City of Albuquerque Stormwater Construction Site Inspection Report

ESC File No.	C17E119	Project Name:	Horizon Village		
NPDES Id. No.	NMR10023E/NMR10023F	Location:	8814 Horizon Blvd.		
6/15/2021	Owner	Contractor			
Operator	Clearbrook Investments	Stillbrooke Homes			
Contact name & title	Chris Kelsey				
e-mail	ckelsey@stillbrooke.com				
Contact Phone #	858-1800				
COA Inspector	Thomas Evans	Start/End Time:	9:45 AM-9:50 AM		
Construction Phase:	idle				
Type of Inspection:		Storm Event	Past Storm Event >0.25"	311/Complaint	Follow Up
Weather at time of inspection?	clear	Temperature: ~		80	
Estimated date of last storm 0.25" or greater	5/31/2021

EROSION AND SEDIMENT CONTROL PLAN

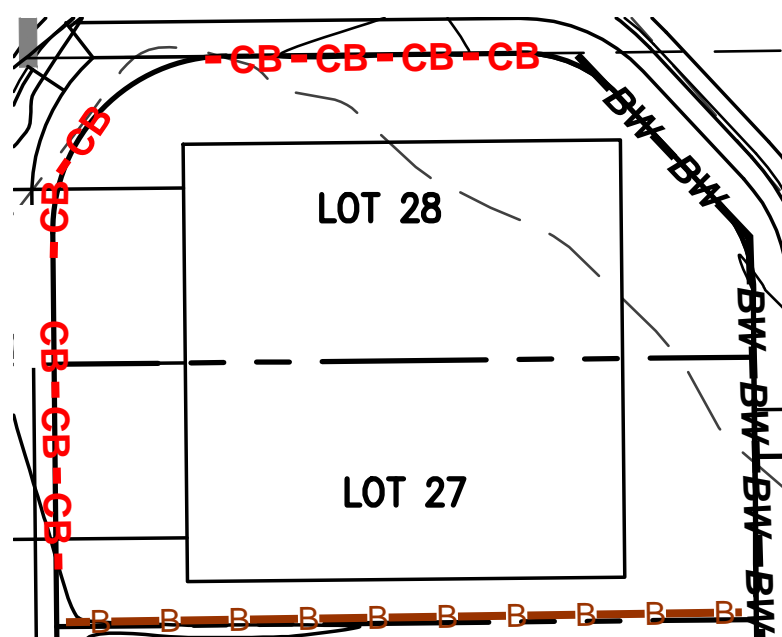
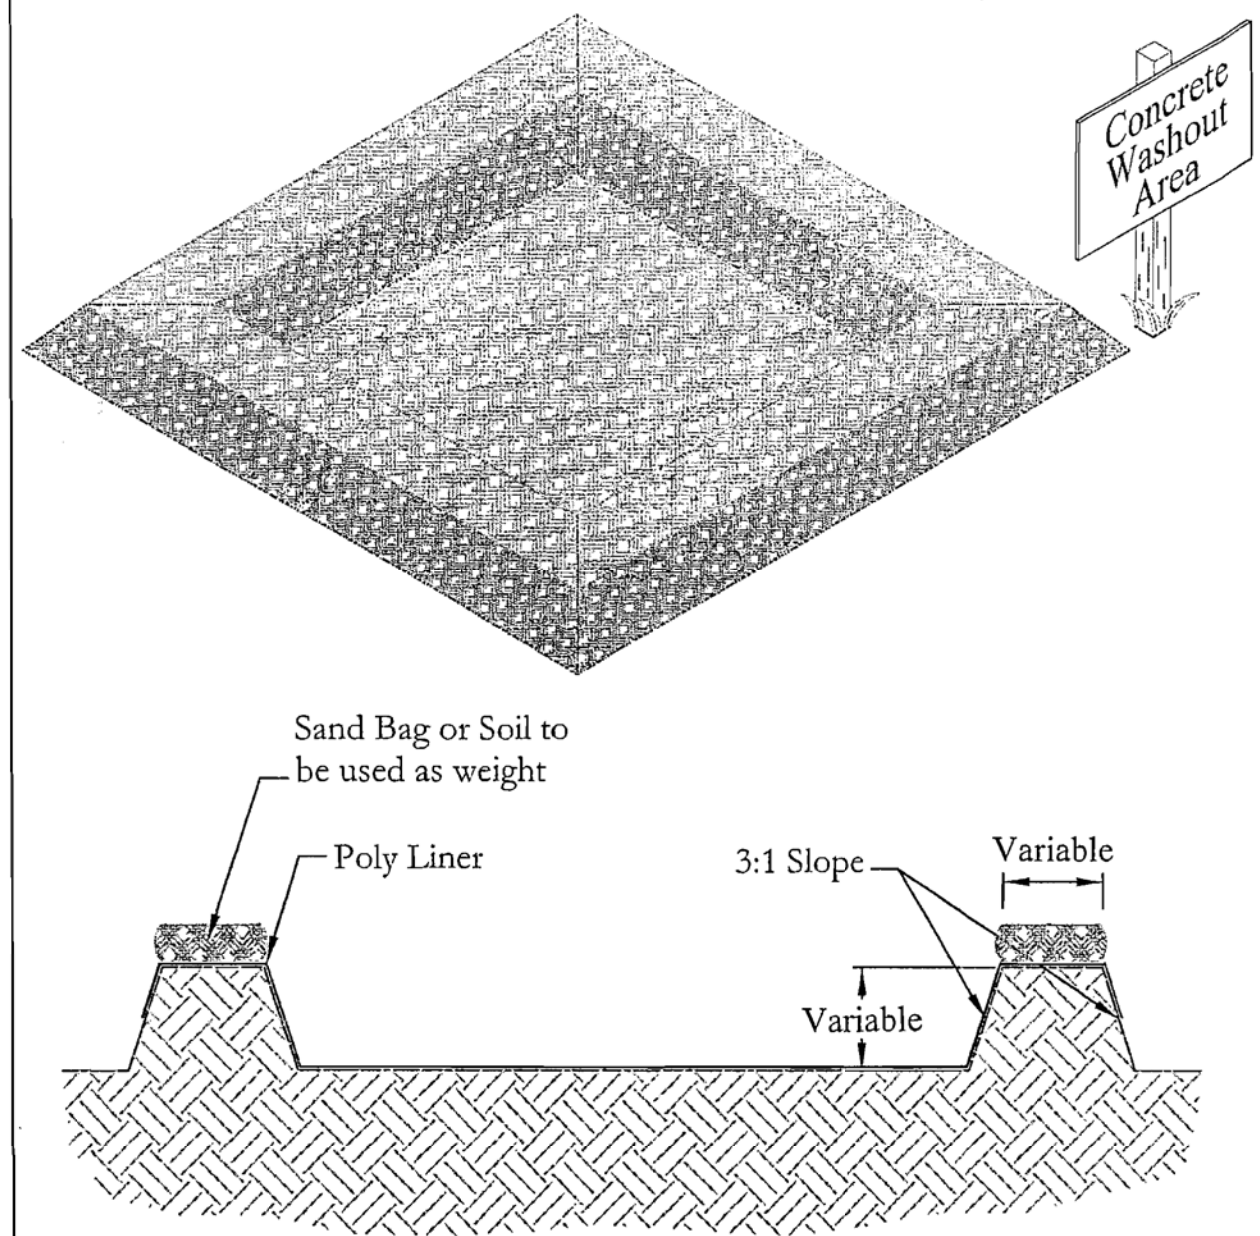
Item Number	Deficiency/ Corrective Action				
1	No posting of permit coverage. Post NOI permit coverage in a location clearly visible to the public. The location of the SWPPP must also be identified on the sign.				
2	Sediment in the street. Sweep and remove sediment in the street.				
3	Silt fences are down or missing (south cul-de-sacs). Maintain silt fences.				
4	Areas of the site are not stabilized.
